RE: GEOTECHNICAL THIRD-PARTY REVIEW, 5637 EAST MERCER WAY,
CITY OF MERCER ISLAND PROJECT NO. CAO15-001

This letter summarizes our third-party geotechnical review for the proposed development at 5637 East Mercer Way, Mercer Island, Washington. The documents that we reviewed are listed at the end of this letter. Several documents were prepared as part of a previous geotechnical third-party review by Perrone Consulting, Inc. (Perrone). Additional geotechnical documents were issued by the Applicant's geotechnical engineer, Geo Group Northwest (GGNW) after Perrone completed their review.

<p>THE HEALEY ALLIANCE AZ 2505 N 25th DRIVE, GOODYEAR, AZ 85526 • (480) 444-6766 ARCHITECTS</p>	<p>Mi Treshouse, LLC, 5631 EAST MERCER WAY MERCER ISLAND, WA.</p>	<p>SITE PLAN DATE: 03/20/24 DRAWN BY: [Name] CHECKED BY: [Name] SCALE: 1" = 20'</p>
--	---	--	--

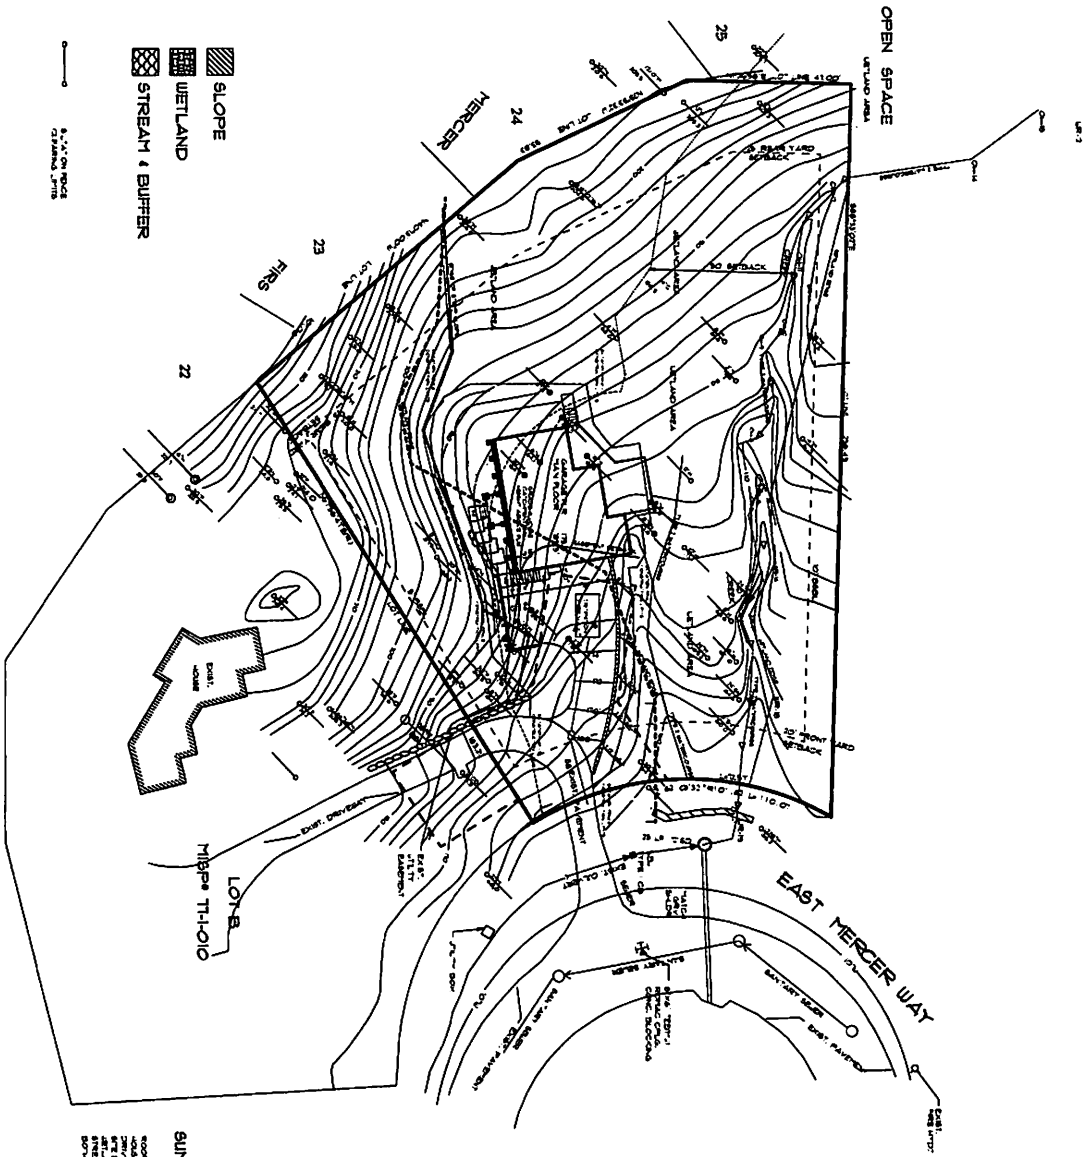
2. Please confirm that the Site Plan dated August 9, 2018 by Healey Architects is the current version or provide updated design drawings if available. The drawings should show the location and elevation(s) of the proposed residence; elevation contours; excavation locations and depths; proposed fill areas and thicknesses, and retaining structure locations, types, and top/toe elevations.
